Stonestreet Green Solar

Signed Statement of Common Ground with the Environment Agency (Tracked)

Doc Ref. 8.3.2(B)

Version 3

2.7(A) Illustrative Landscape Drawings

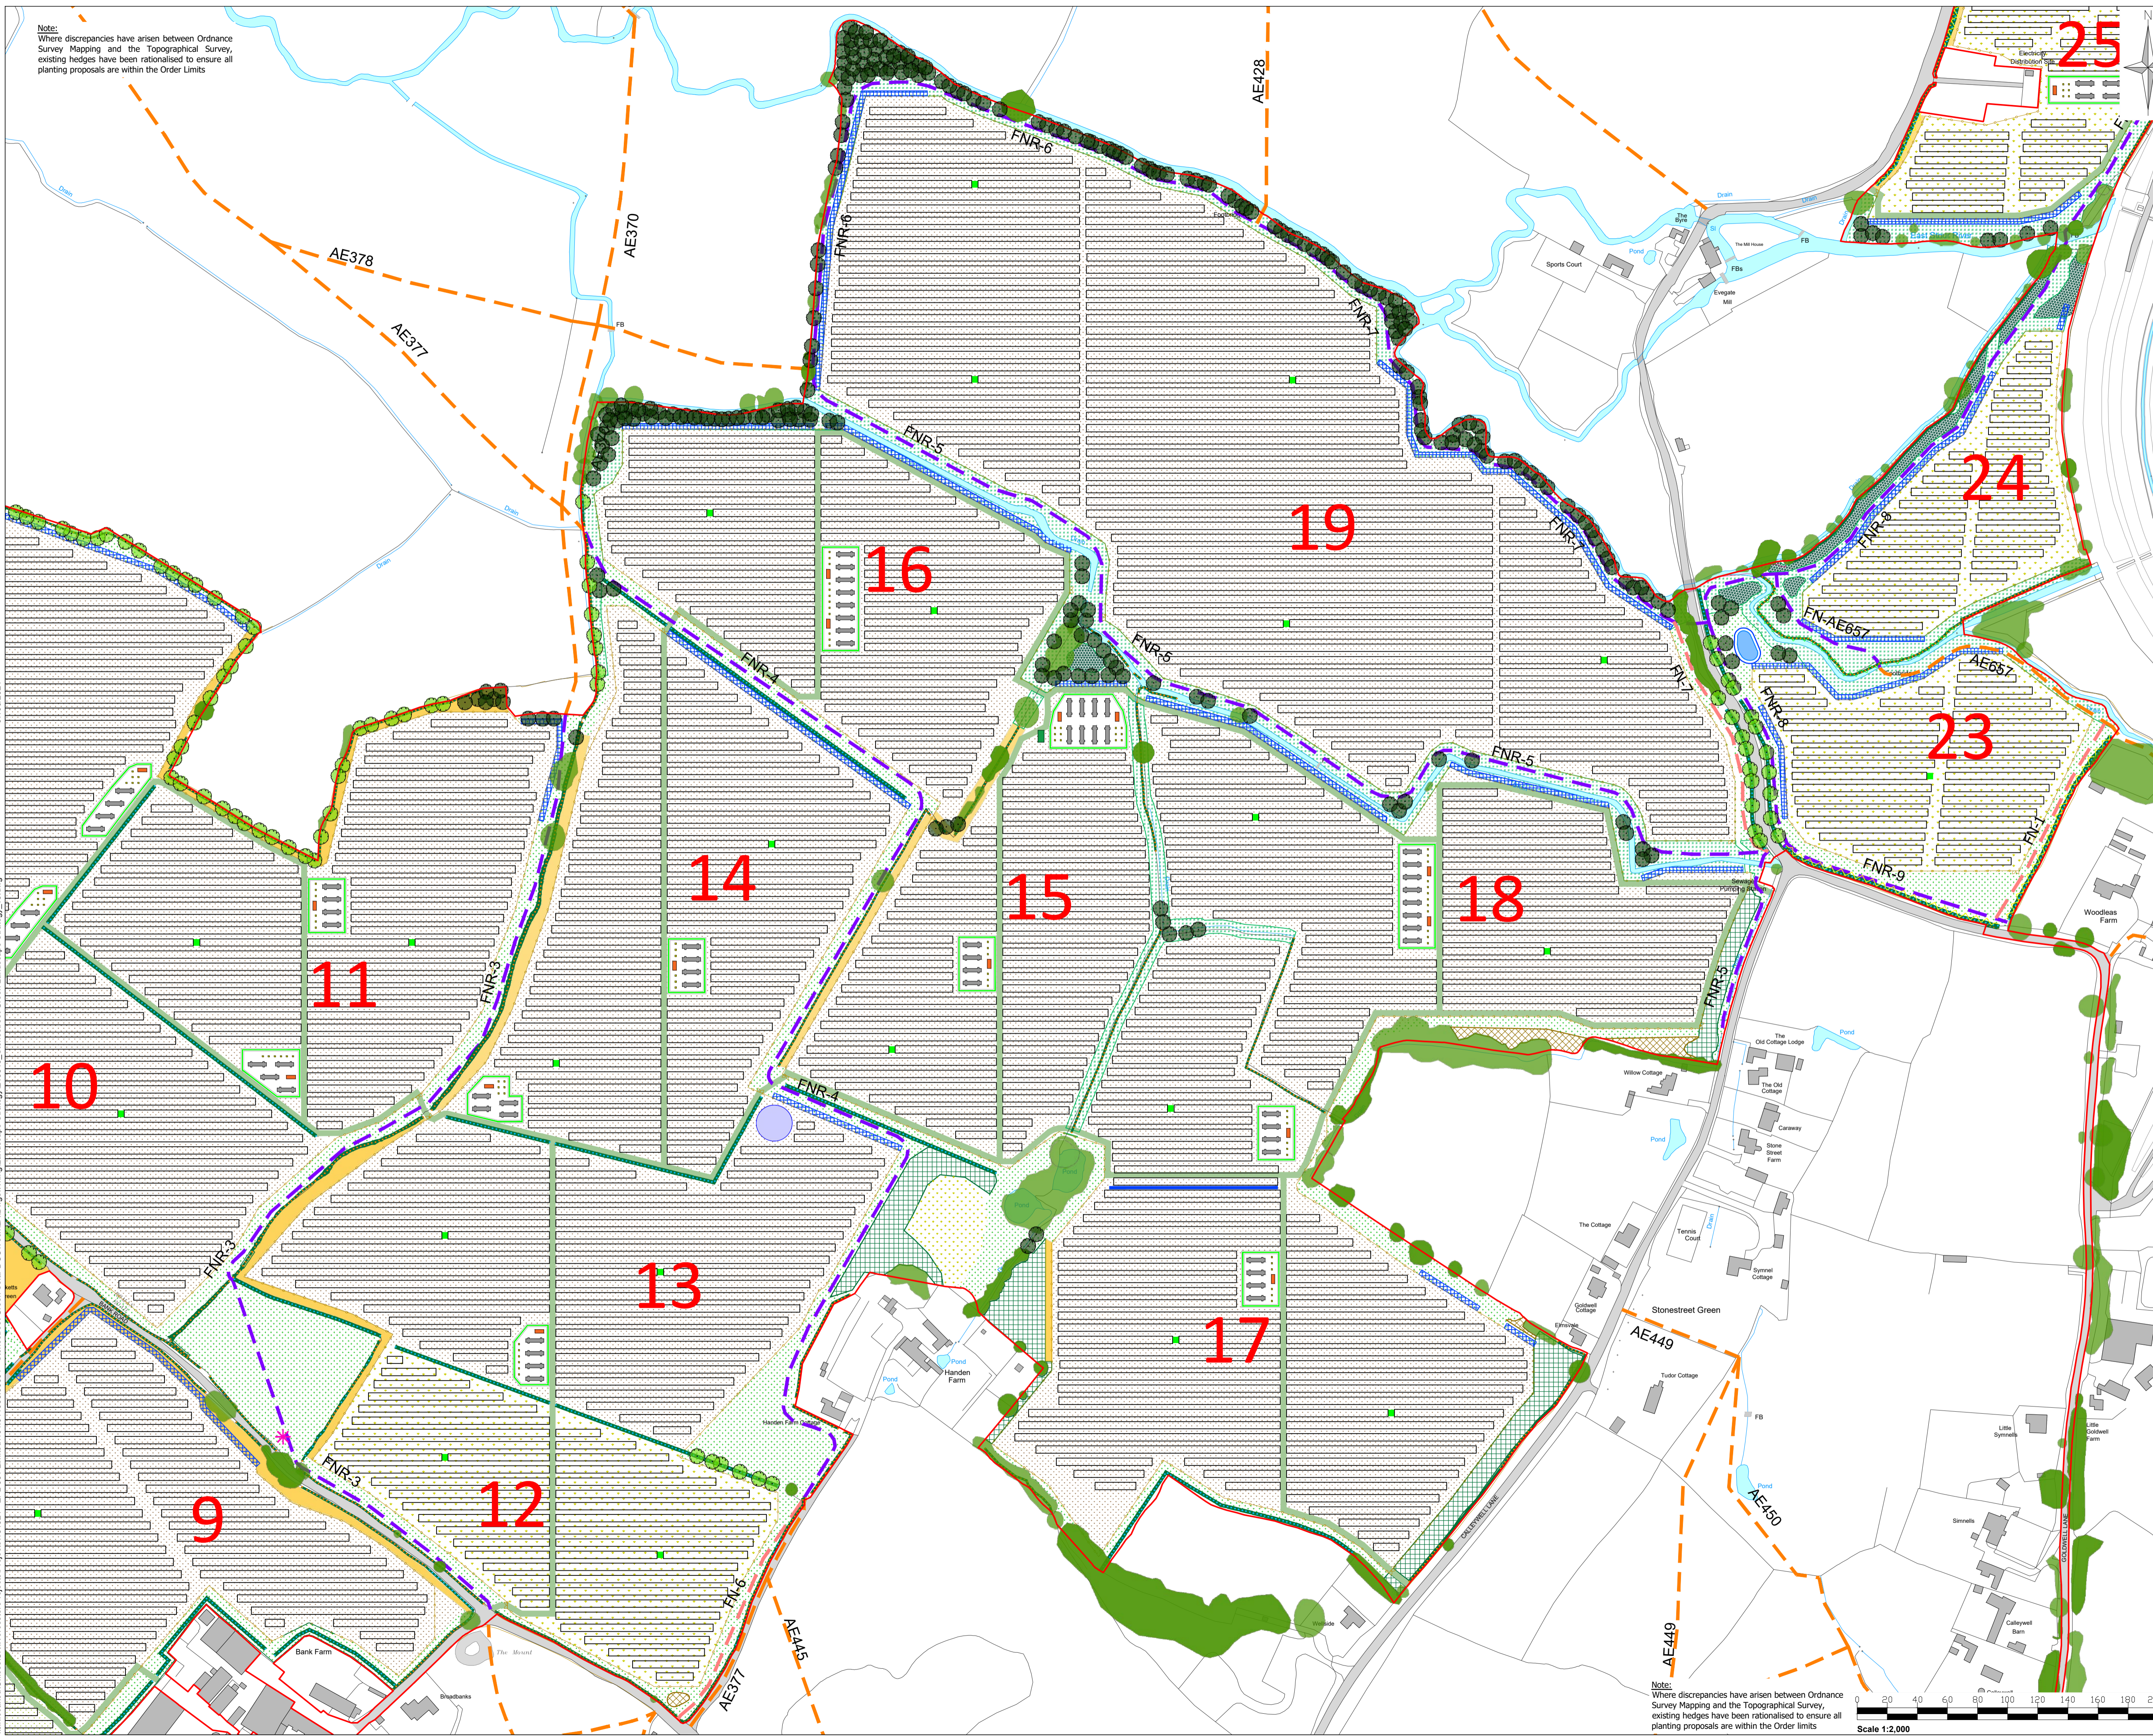
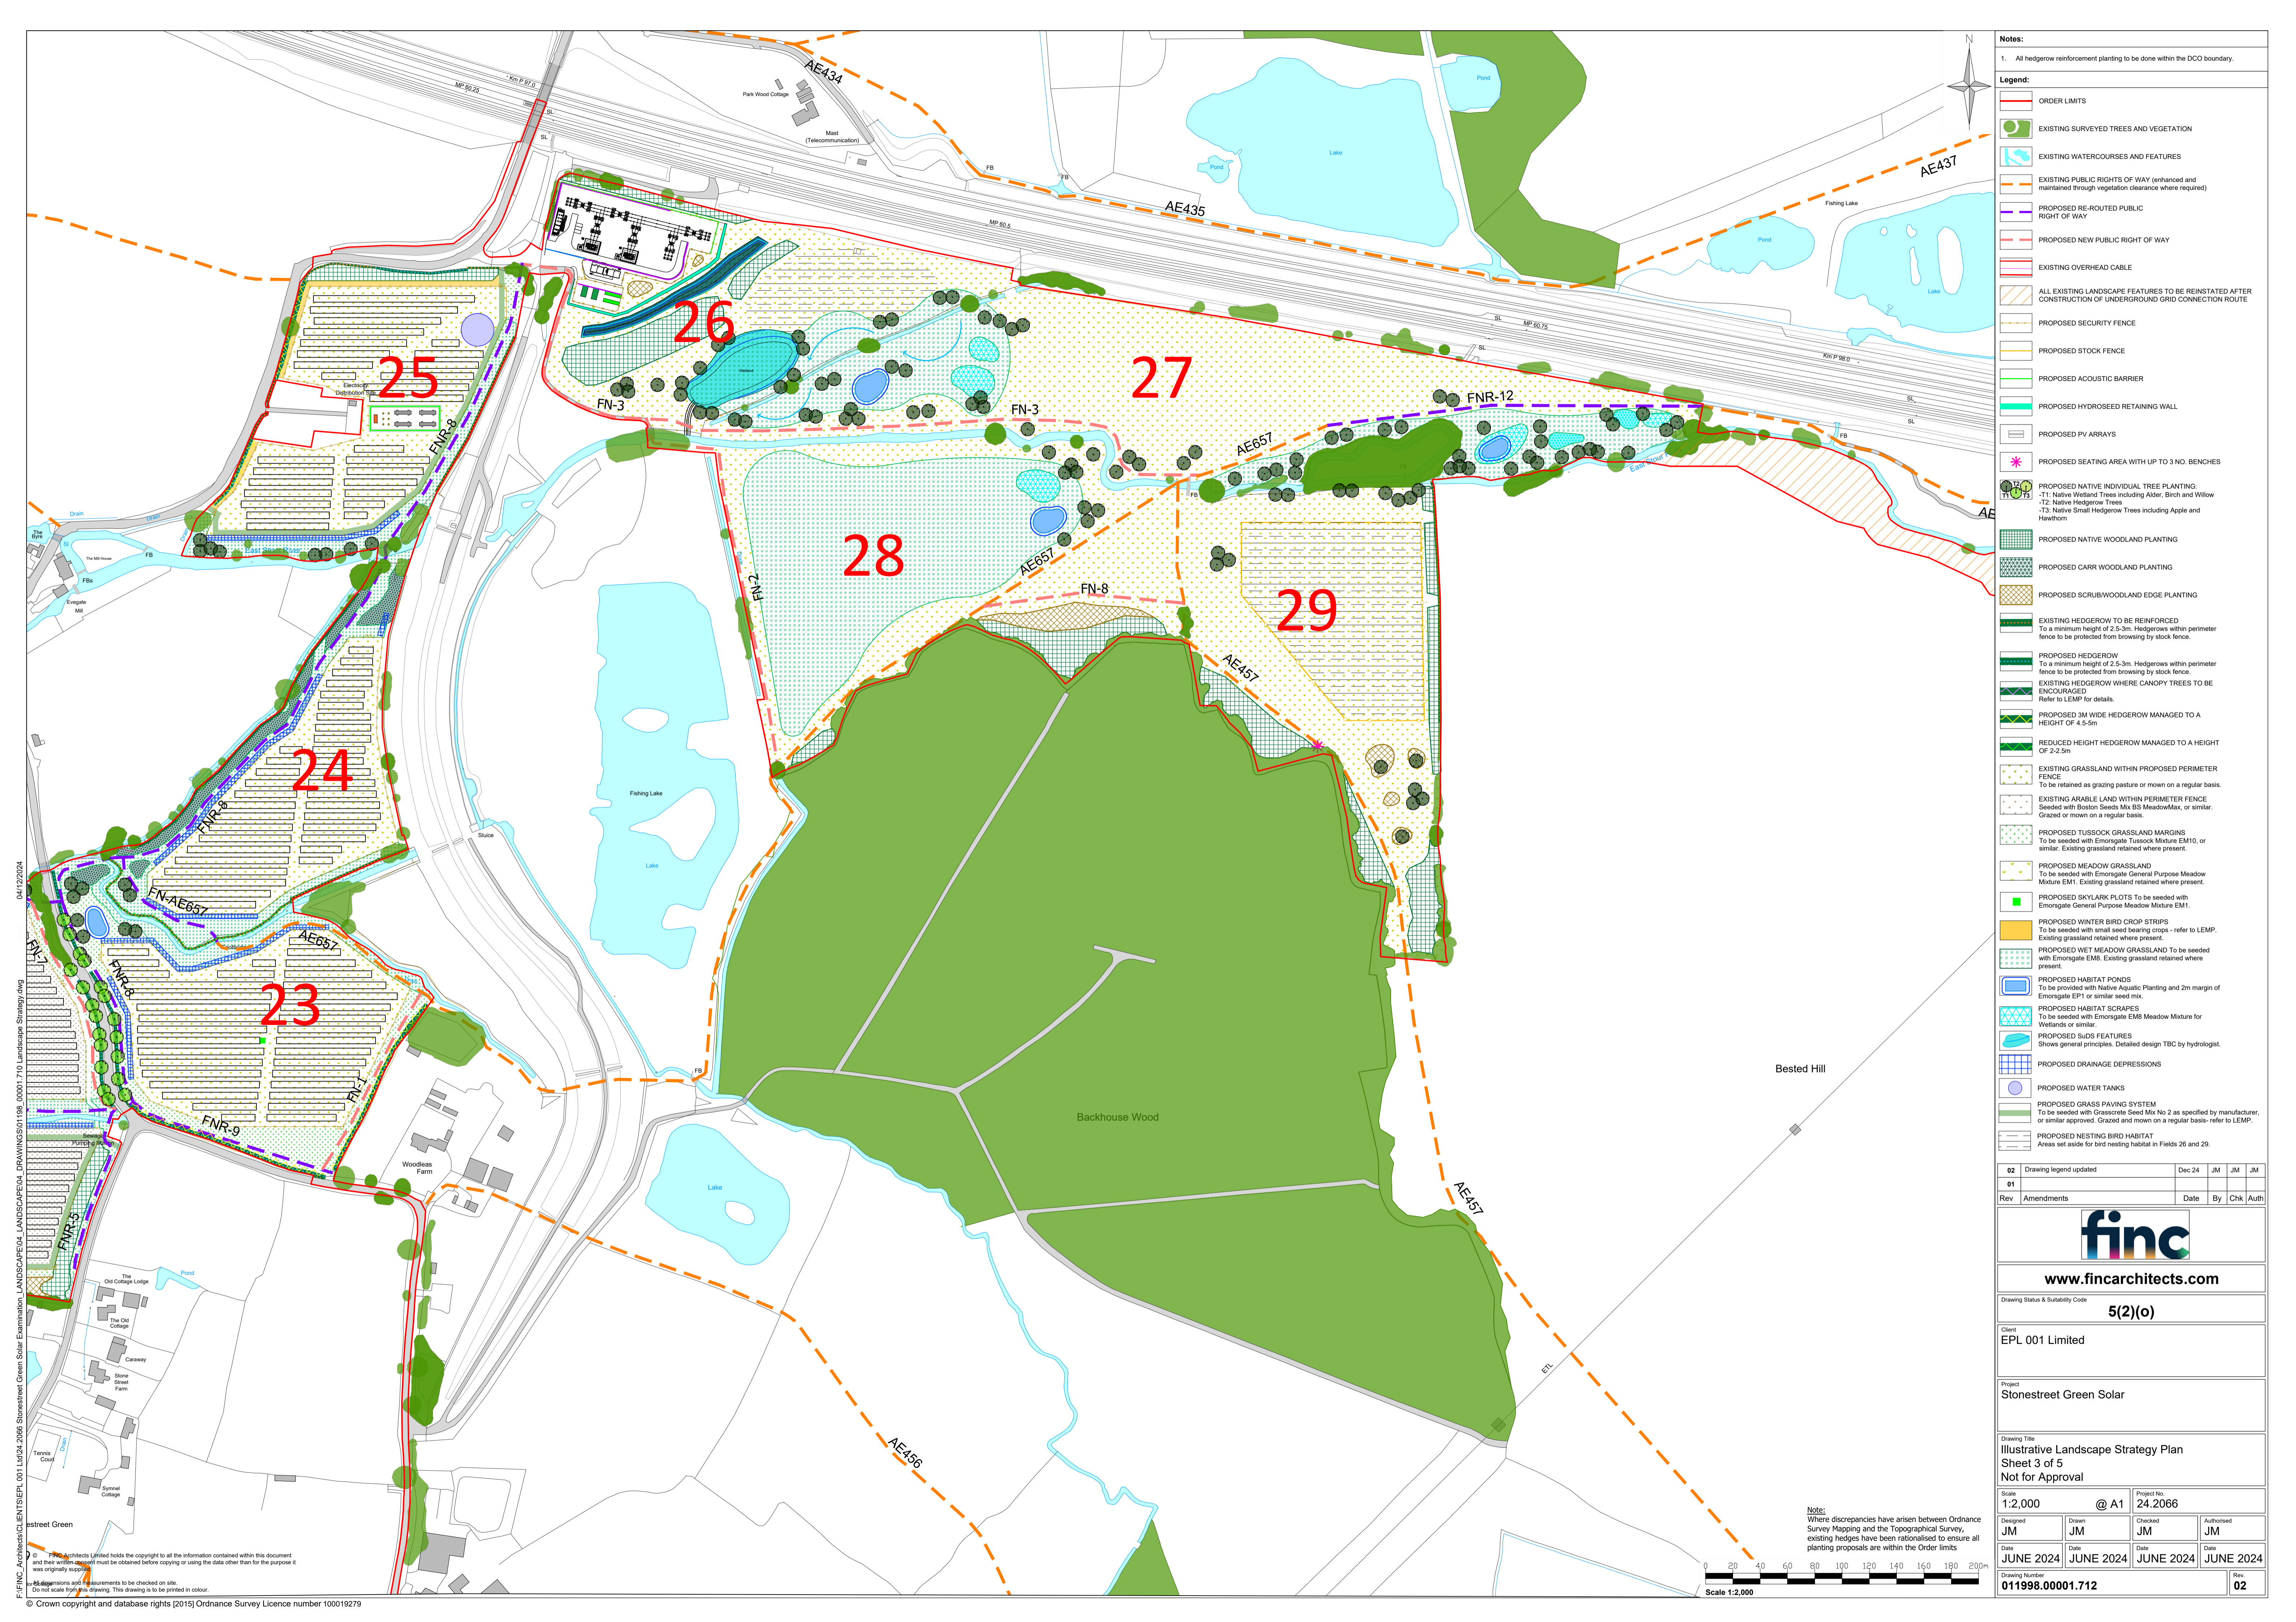
Ref	Relevant Application Document	Description of Matter	EA Current Position	Applicant's Current Position	Status
2.10 to 12	RR	Issue 3 - Flood Storage Calculations	Situation: The 'Floodplain Compensation level for Level Calculation' table from 'Annex D: Floodplain Compensation Level for Level Calculations' of the FRA demonstrates a net increase (1,543.11 m3) in flood storage downstream of the Aldington Flood Storage Area but does not show any net increase within Aldington Flood Storage Area as referenced in the Outline Operational Surface Water Drainage Strategy (OOSWDS). Paragraph 5.1.5 of the OOSWDS states "The swale and wetland areas have both been designed to enhance biodiversity and ensure that there is no adverse impact on water quality. In addition, the wetland area, which will be sited within the AFSA, will increase the capacity of fluvial flood storage available. This will therefore contribute to a small reduction in downstream flood risk." (<i>APP-094 – Doc 5.4 Environmental Assessment Appendix 10.2: Flood Risk Assessment; APP-159 – Doc 7.14</i>)	None of the works proposed within the AFSA involve any build up in ground levels. The works proposed relate to; 1. Superficial treatments and vegetation management with a commitment made that vegetation management will be ongoing with any accumulated material removed from the AFSA. Such work would therefore have a neutral impact on flood storage, 2. The provision of fencing around the skylark area in Field 29 as illustrated on the Illustrative Landscape Drawings (Doc Ref. 2.7(A)) [REP1-005]2.7(B)) (Sheet 3 of 5 - drawing number 011998.00001.712). The fence posts would result in a negligible loss of flood storage, but at a level that would be difficult to quantify. 3. The creation of ecological scrapes and ponds as illustrated on the Illustrative Landscape Drawings (Doc Ref. 2.7(A)) [REP1-005] (Sheet 3 of 5—	Under discussion Agreed

Ref	Relevant Application Document	Description of Matter	EA Current Position	Applicant's Current Position	Status
			<i>Outline Operational Surface Water Drainage Strategy</i> Impact: The storage capacity of Aldington Flood Storage Area may be reduced by the proposed landscaping works. Solution: The applicant should amend the flood storage calculations within the 'Floodplain Compensation level for Level Calculation' table from 'Annex D: Floodplain Compensation Level for Level Calculations' of the FRA to show the flood storage increase inside Aldington Flood Storage Area as stated in the paragraph 5.1.5 of the OOSWDS "increase the capacity of fluvial flood storage available". 22/11/2024 (EA) As outlined above when the Outline OSWDS (Doc Ref. 7.14) is updated to include that there will be no net loss of storage capacity within the AFSA this will be conditioned. We have no further comments to make until we have reviewed the requested supporting calculations and updates to Environmental Statement	drawing number 011998.00001.712.2.7(B)) (Sheet 3 of 5 - drawing number 011998.00001.712). These would be formed by excavation only with all spoil removed disposed of outside of the AFSA. As such these works would only increase the available flood storage volume. 4. The creation of the wetland area which will receive storm runoff from the Project Substation. This will be formed by excavation and will not involve impounding water to a level above the existing ground surfaces. As such the formation of this feature can only increase the volume of flood storage available. The net effect of these works will clearly be an increase in the available flood storage volume within the AFSA. On this basis no further assessment was deemed necessary. In response to this comment work is however now being undertaken to quantify the changes resulting from items 2, 3 and 4 above. This

Ref	Relevant Application Document	Description of Matter	EA Current Position	Applicant's Current Position	Status
2.13	RR	Issue 3 - Flood Storage Calculations	Solution: The applicant should also confirm that there is no loss of flood storage capacity in Aldington Flood Storage Area from the landscaping works including but limited to the woodland planting, tree planning, habitat scrapes and habitat ponds. 22/11/2024 (EA) No further comments, our above comments for Issue 2.10 to 12 apply. <u>16/01/2025 (EA) We have reviewed the updated Flood Risk Assessment (FRA) (Doc Ref. 5.4(A)) dated December 2024 and we are satisfied with it. Our above comments for Issue 2.10 to 2.12 apply. Status changed as "Agreed"</u>	As above	<u>Under discussion</u> <u>Agreed</u>

Ref	Relevant Application Document	Description of Matter	EA Current Position	Applicant's Current Position	Status
			Appendix 10.2: Flood Risk Assessment (Doc Ref 5.4) <u>16/01/2025 (EA) We have reviewed the updated Outline OSWDS (Doc Ref. 7.14(A)) dated December 2024 which now includes commitment in section 4.6.8 that the Project would not result in a net loss of storage capacity with the AFSA.</u> <u>Section 4.6.8 of the Outline OSWDS states "The wetland area also provides the benefit of creating additional storage within the Aldington Flood Storage Area. This effect is quantified in ES Volume 4, Appendix 10.2: Flood Risk Assessment (Doc Ref. 5.4). The final detailed design for this feature, and other small ecological ponds and scrapes, will ensure that there is a net increase in flood storage provided within the Aldington Flood Storage Area." We are satisfied with the changes to the Outline OSWDS.</u>	additional detail will be included within ES Appendix 10.2: Flood Risk Assessment (Doc Ref 5.4(A)) [REP1-036] [REP1-037] and [REP1-038]. The updated document will be provided by Deadline 1. In addition, the Applicant will also amend the Outline OSWDS (Doc Ref. 7.14(A)) [REP1-054] 7.14(B)) to include a commitment to ensure no net loss of storage capacity within the AFSA. The Applicant awaits the EA's confirmation that the updates to the Outline OSWDS (Doc Ref. 7.14(A)) [REP1-054] are acceptable. 7.14(B)) <u>are acceptable.</u>

Ref	Relevant Application Document	Description of Matter	EA Current Position	Applicant's Current Position	Status
			<u>Additionally, we have reviewed the updated Flood Risk Assessment (FRA) (Doc Ref. 5.4(A)) dated December 2024 which now includes level for level flood storage calculations for the land upstream of the AFSA embankment shown in Appendix D 'Upstream of AFSA Embankment: Floodplain Compensation Level for Level Calculations'. Section 11.3.9 of the FRA states "flood storage is increased within the ASFA by 1,684m3." We are satisfied that the FRA now shows a net increase in flood storage capacity within Aldington Flood Storage Area.</u> <u>We note that the Environment Agency has been added as a statutory consultee for the approval of the Detailed OSWDS secured by Requirement 11 of the Draft DCO (Doc Ref. 3.1(C)) which we are satisfied with.</u> <u>Status changed to "Agreed".</u>
